As for the comment on page 34 of Geoquest's report:

If the County is requesting a note be added to the plat for mitigation of seasonally shallow groundwater, I would recommend a note stating:

As noted in the site specific Soils Report for Lot 1, prepared by Geoquest, LLC dated May 27, 2020, seasonally shallow groundwater was encountered at the time of drilling on May 12, 2020. Geoquest, LLC recommends, "the excavation of the foundation components must not penetrate more than 5 feet". The foundation is to rest directly on undisturbed material and be designed for a loading of not greater than 1,500 pounds per square foot. Any design by any engineer is subject to revision based on the result of the open hole observation". A site specific soils report and OWTS evaluation will be required for any future proposed structures on Lot 2. There are no additional hazards on Lot 1 or Lot 2 that cannot be mitigated with appropriate planning, engineering and local construction practices.

# Jeanette Mose Subdivision

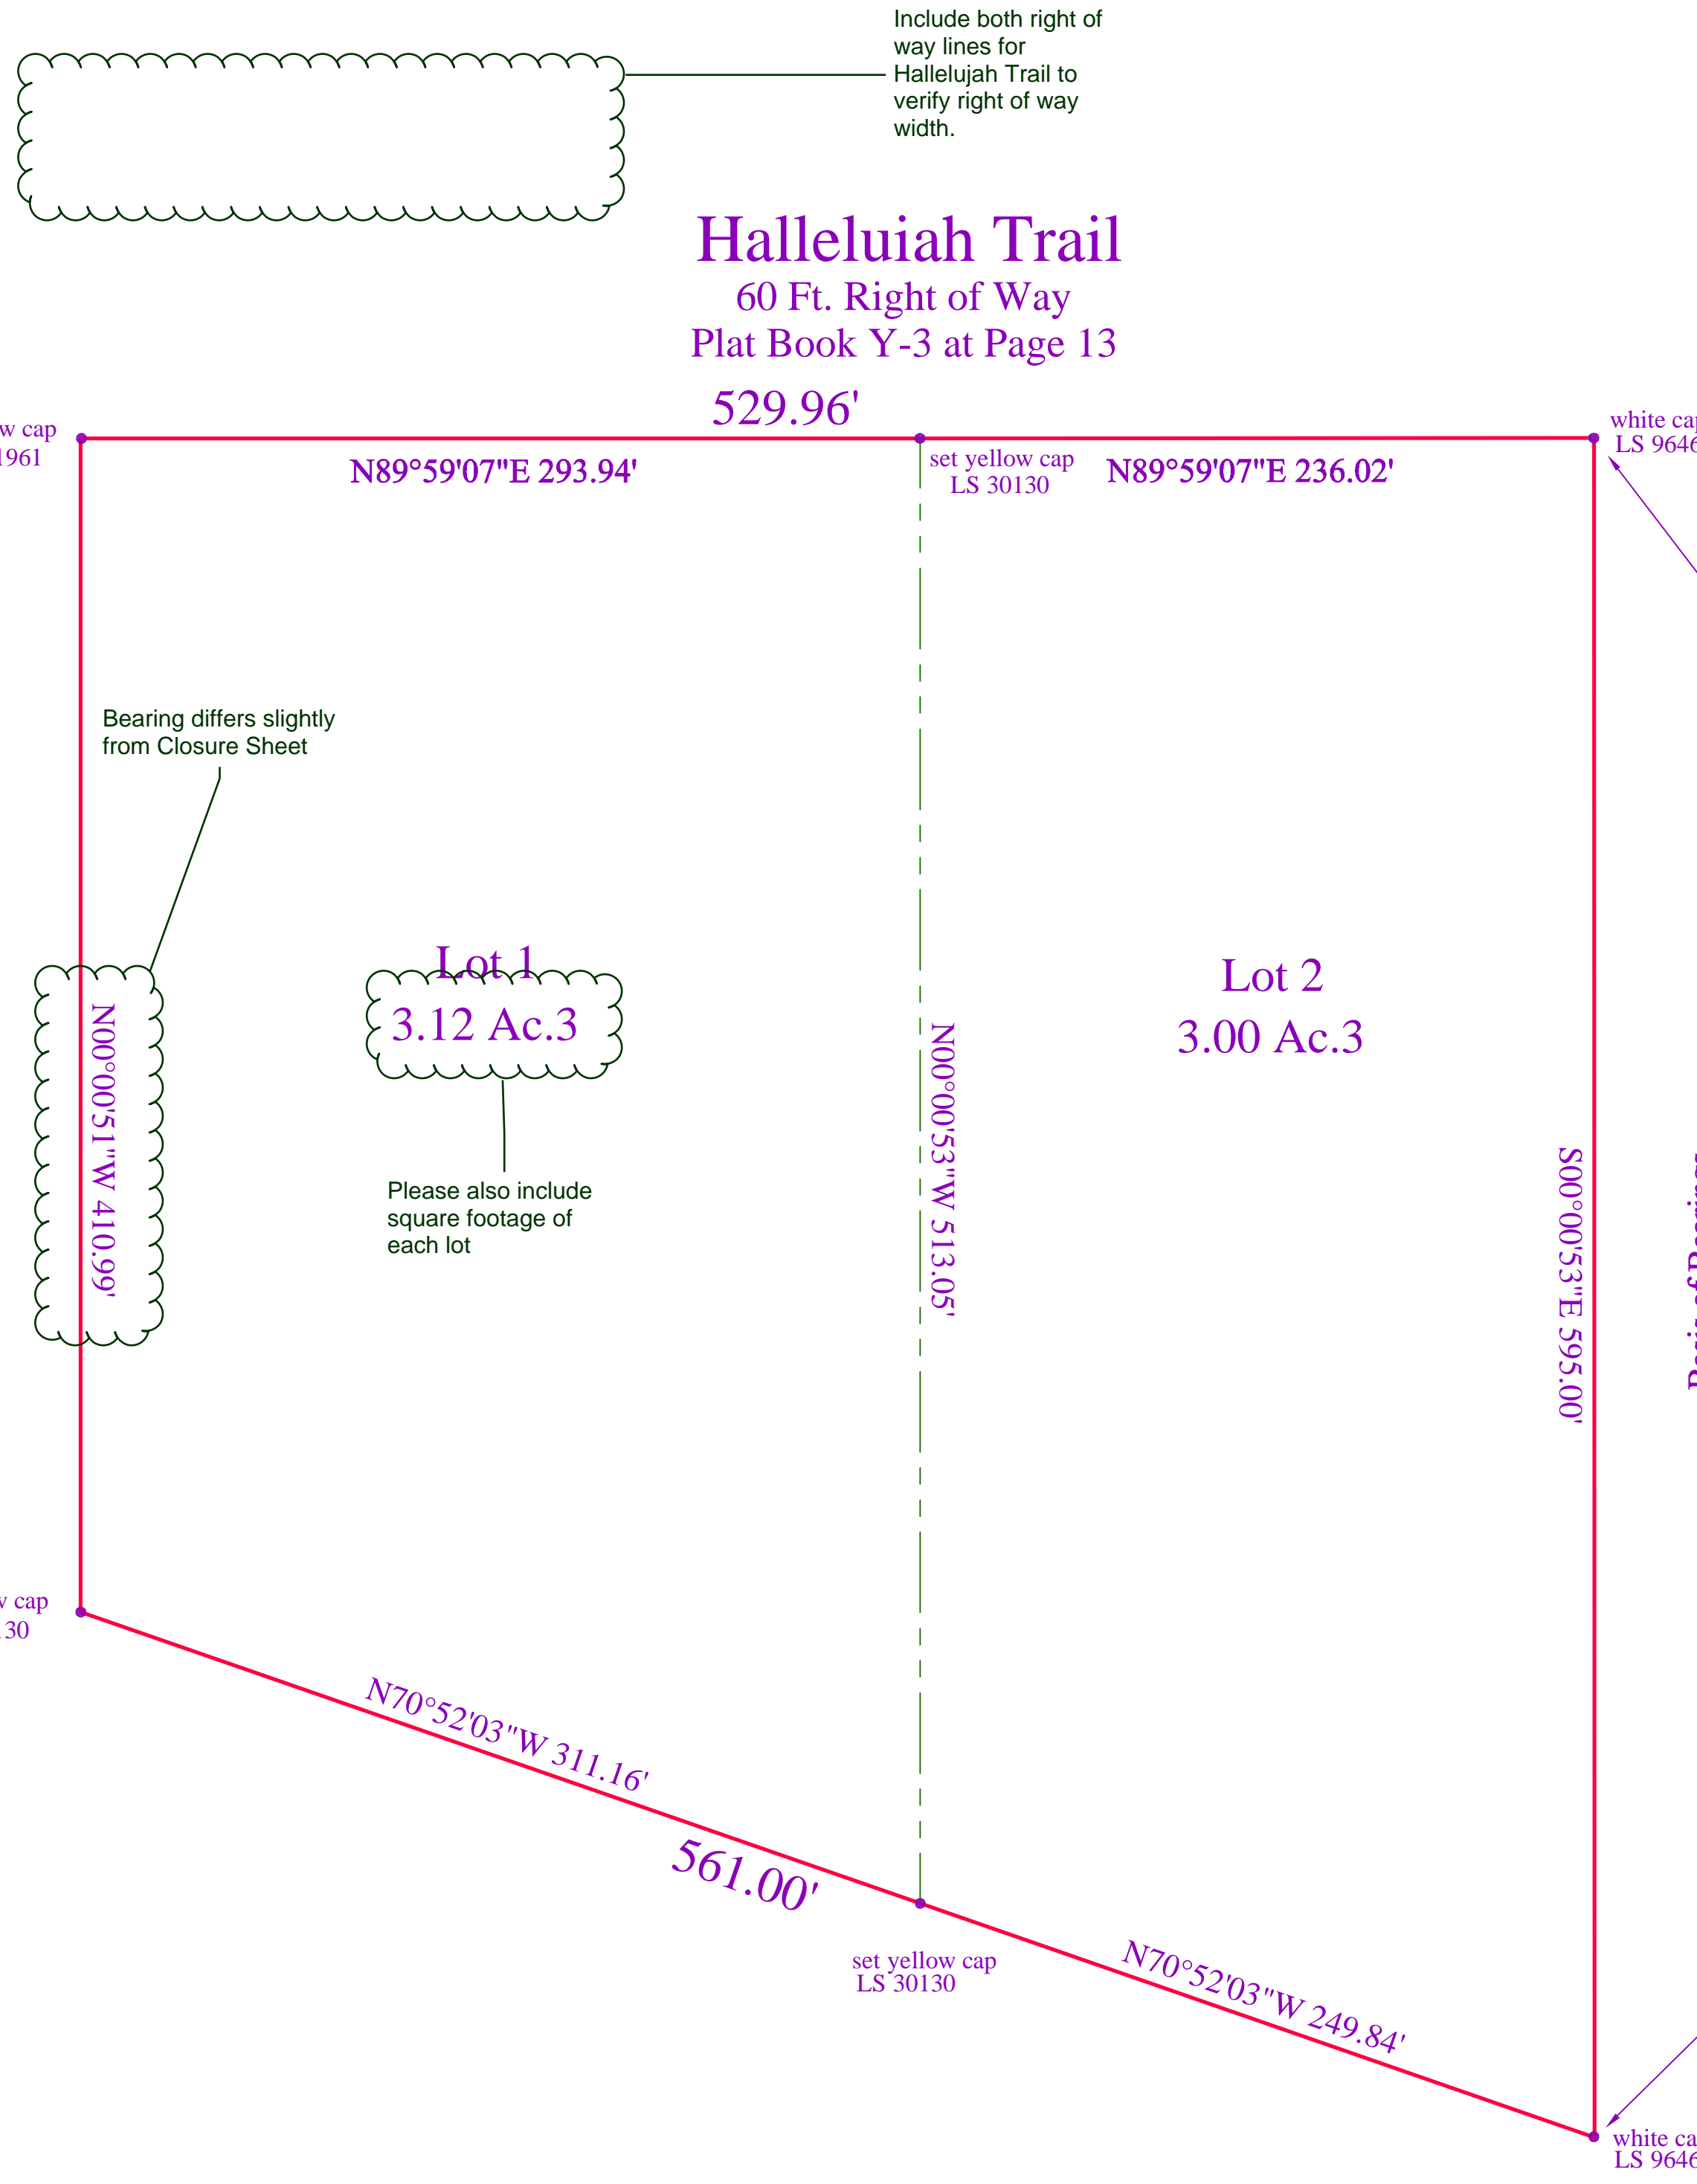
Mitigation should be added as a plat note

Hazard areas that cannot be mitigated must be shown on plat as no-build areas. Please provide graphic indicating hazard areas within site.

At this time, I do not believe we need to revise the reports, if you have any questions let me know. Thank you.
